Ref; Planning Application BE/60/15/PL

To be discussed at the Development Control Committee Meeting 23rd September 2015

Dear Councillor

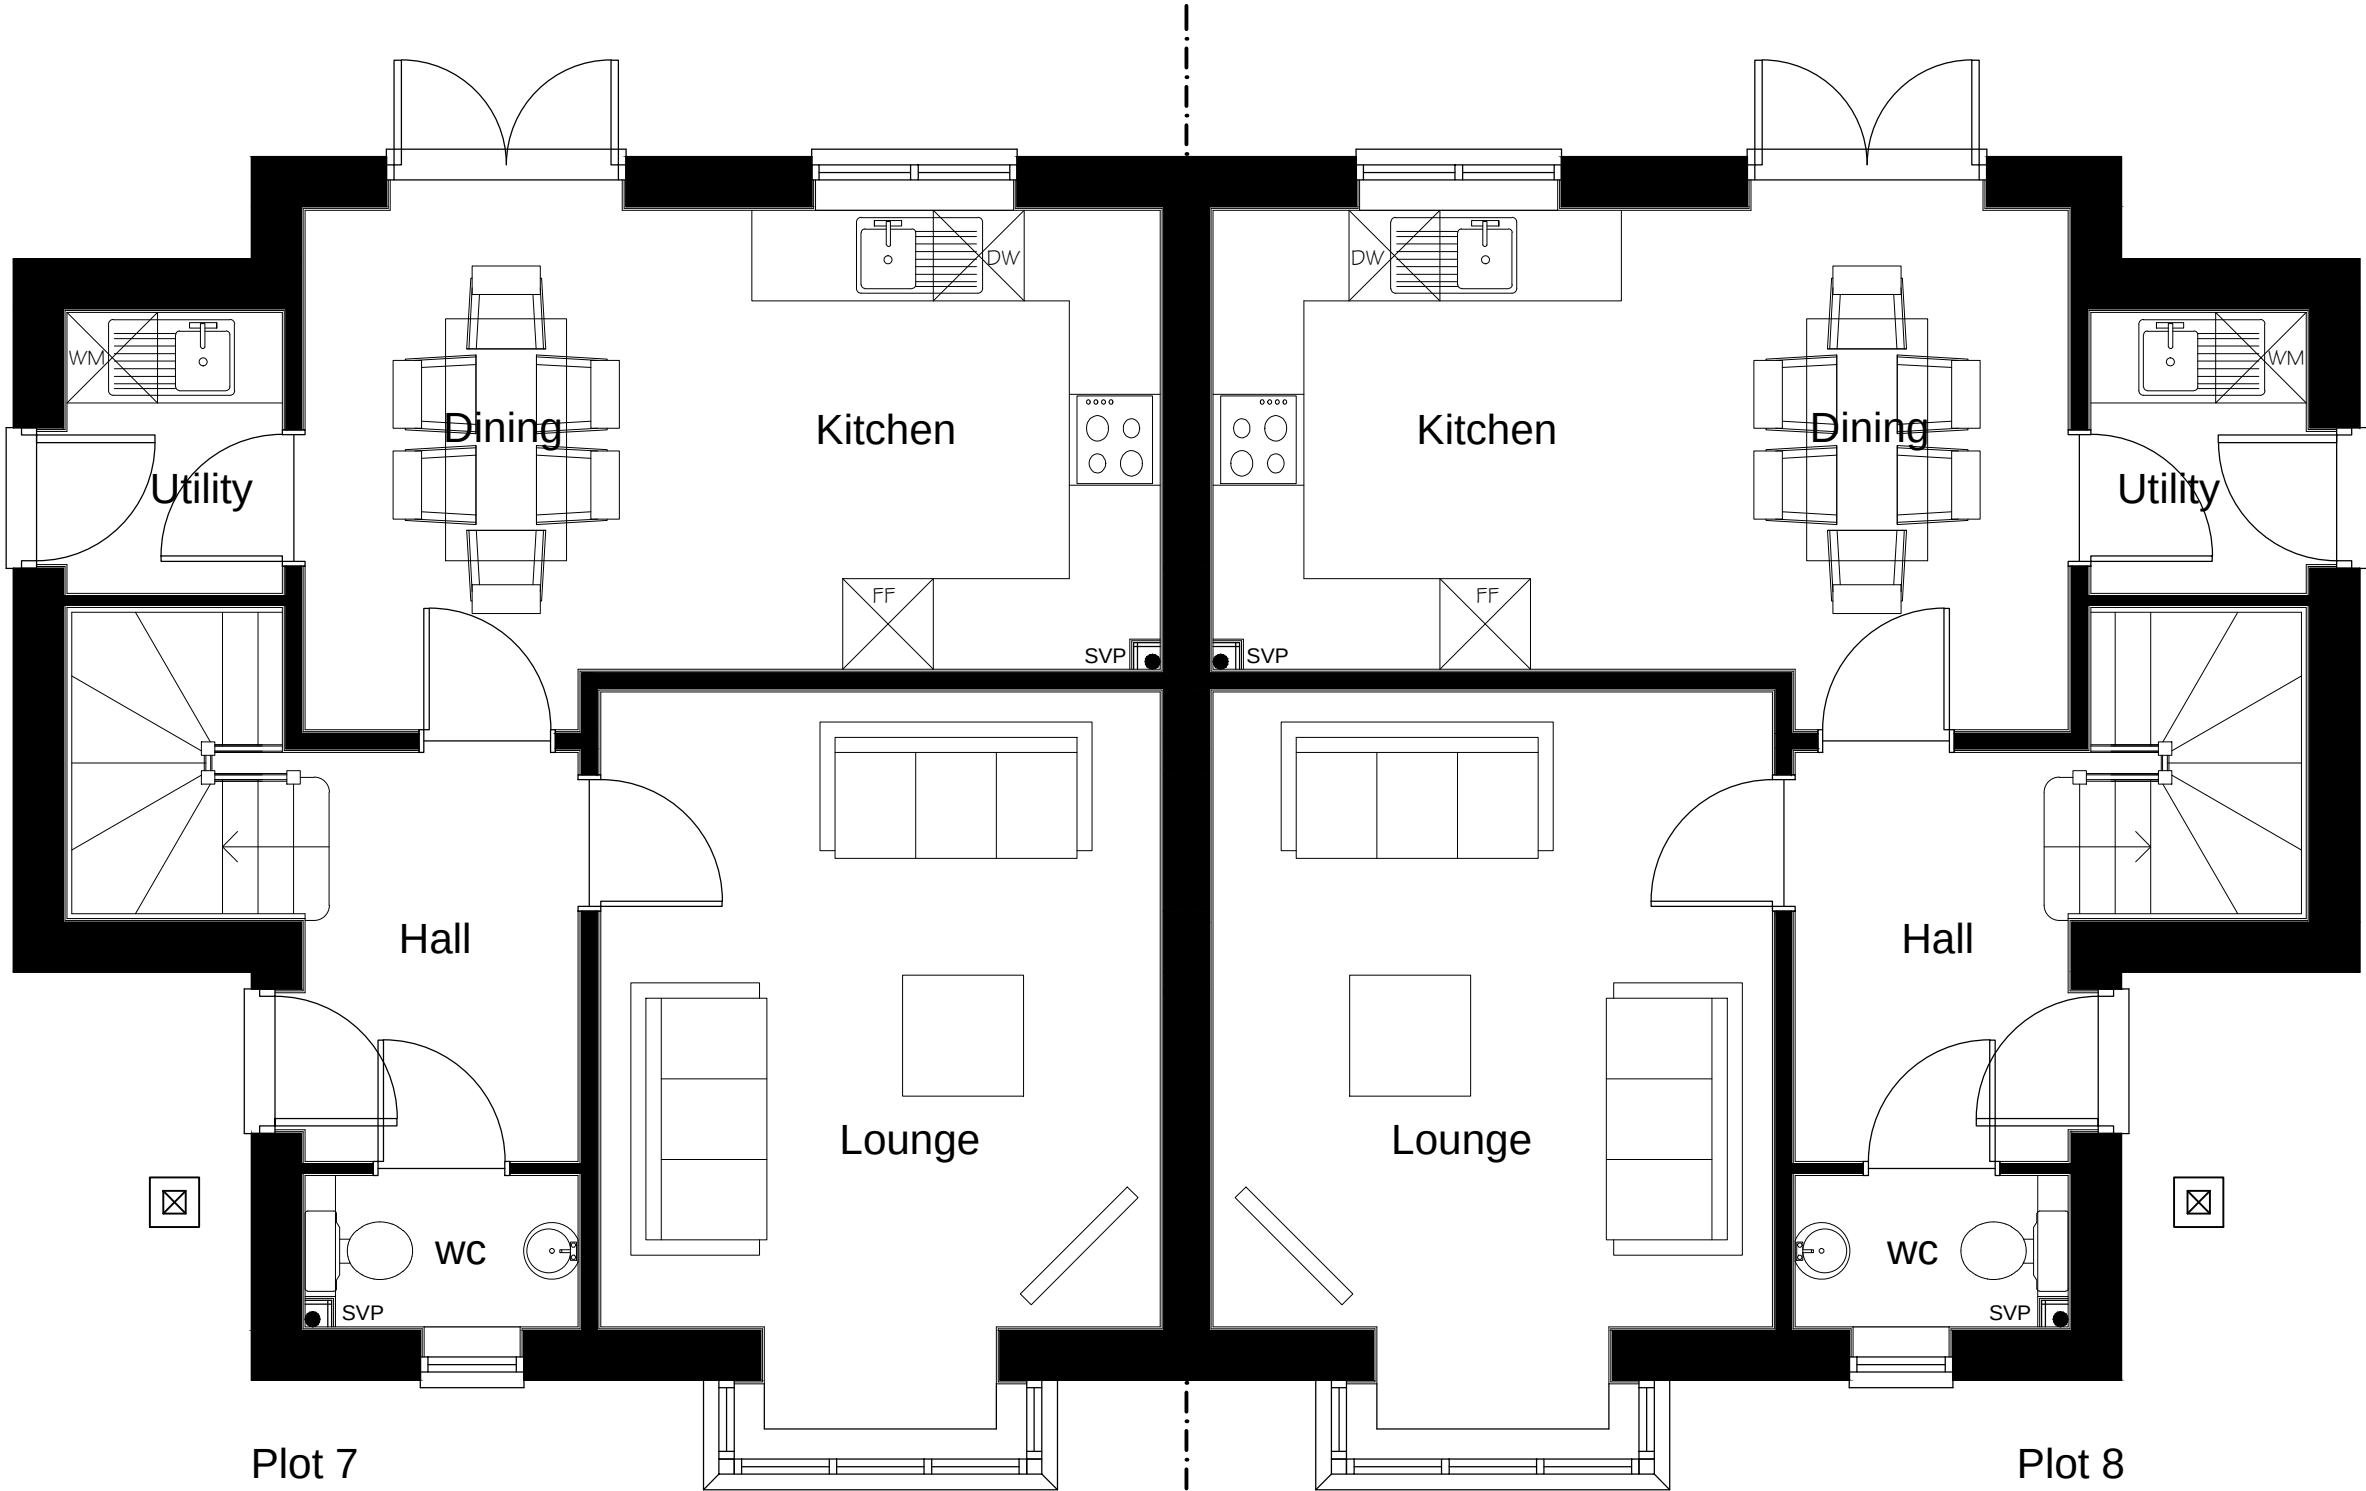
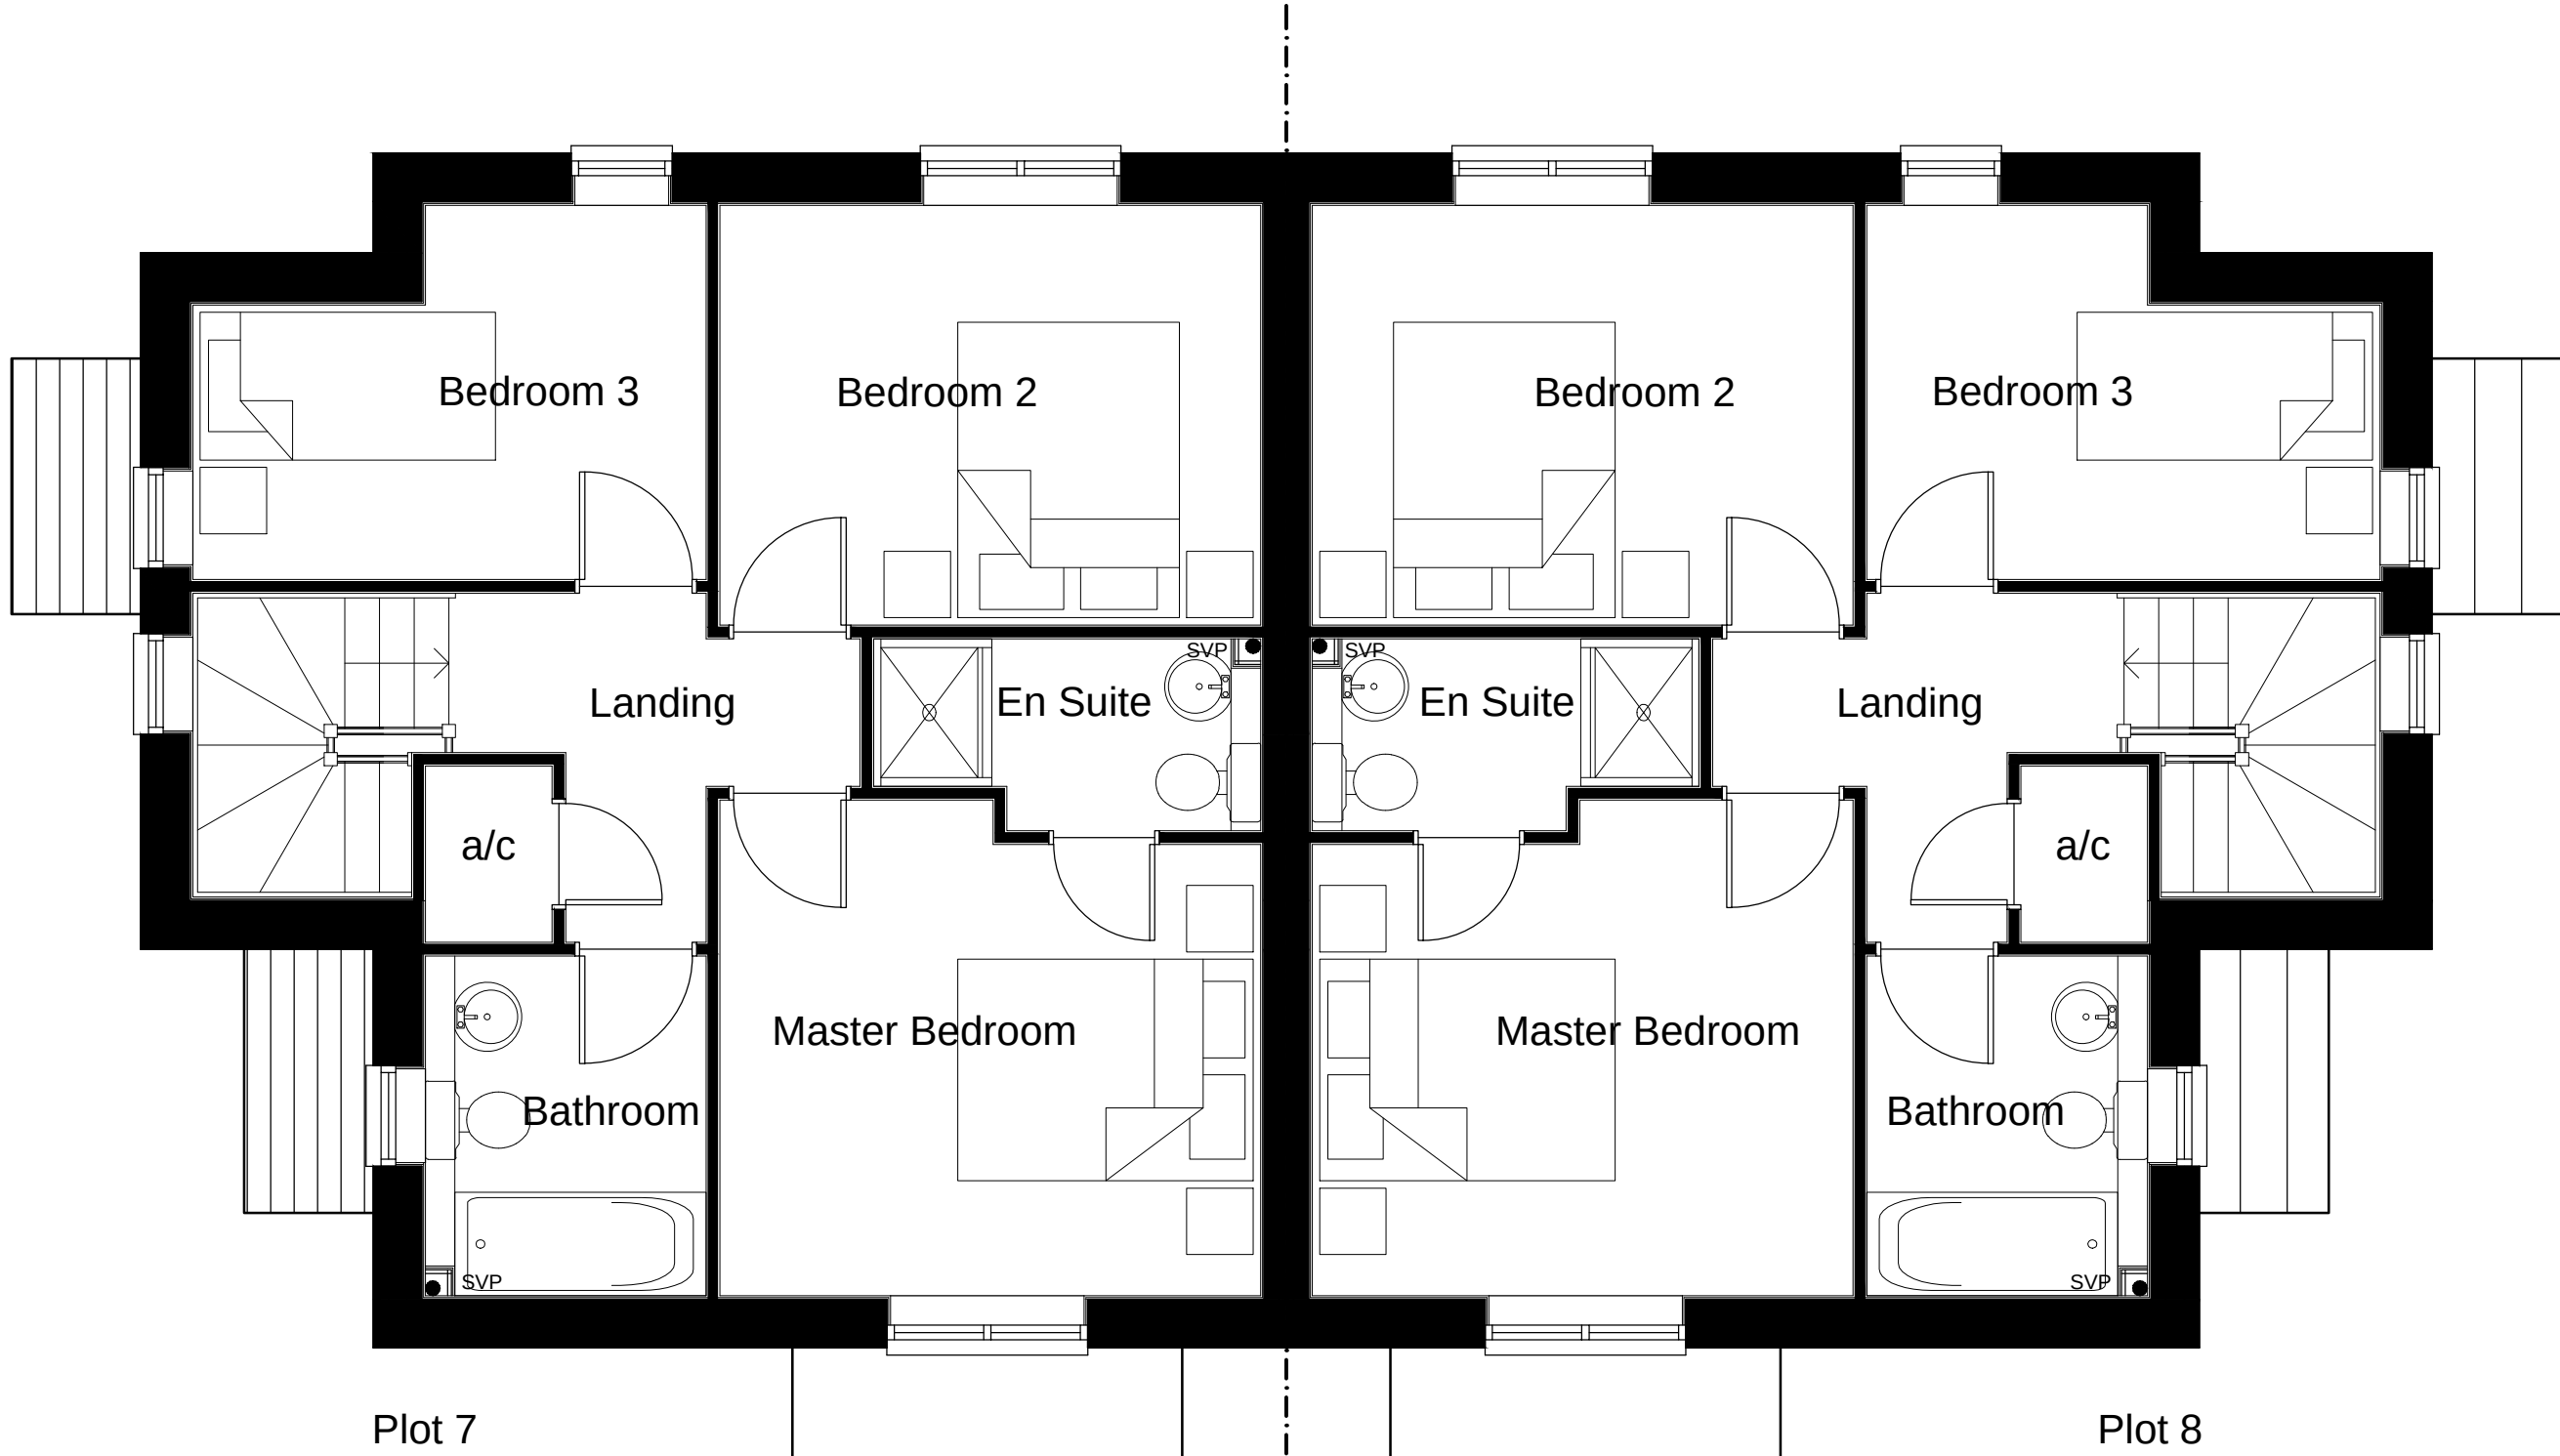
- There is unacceptable noise and disturbance to 15 & 17 by the changed vehicle parking and manoeuvring to plots 7 & 8.
- The first floor windows comprising bedroom 3, landing and bathroom of plot 8 over look existing numbers 15 and 17. These properties are occupied by the vulnerable elderly and young families. The windows are unneighbourly, directly compromise the privacy of these residents and would form an unsatisfactory backland development which would harm the privacy and quiet enjoyment of these neighbouring properties.
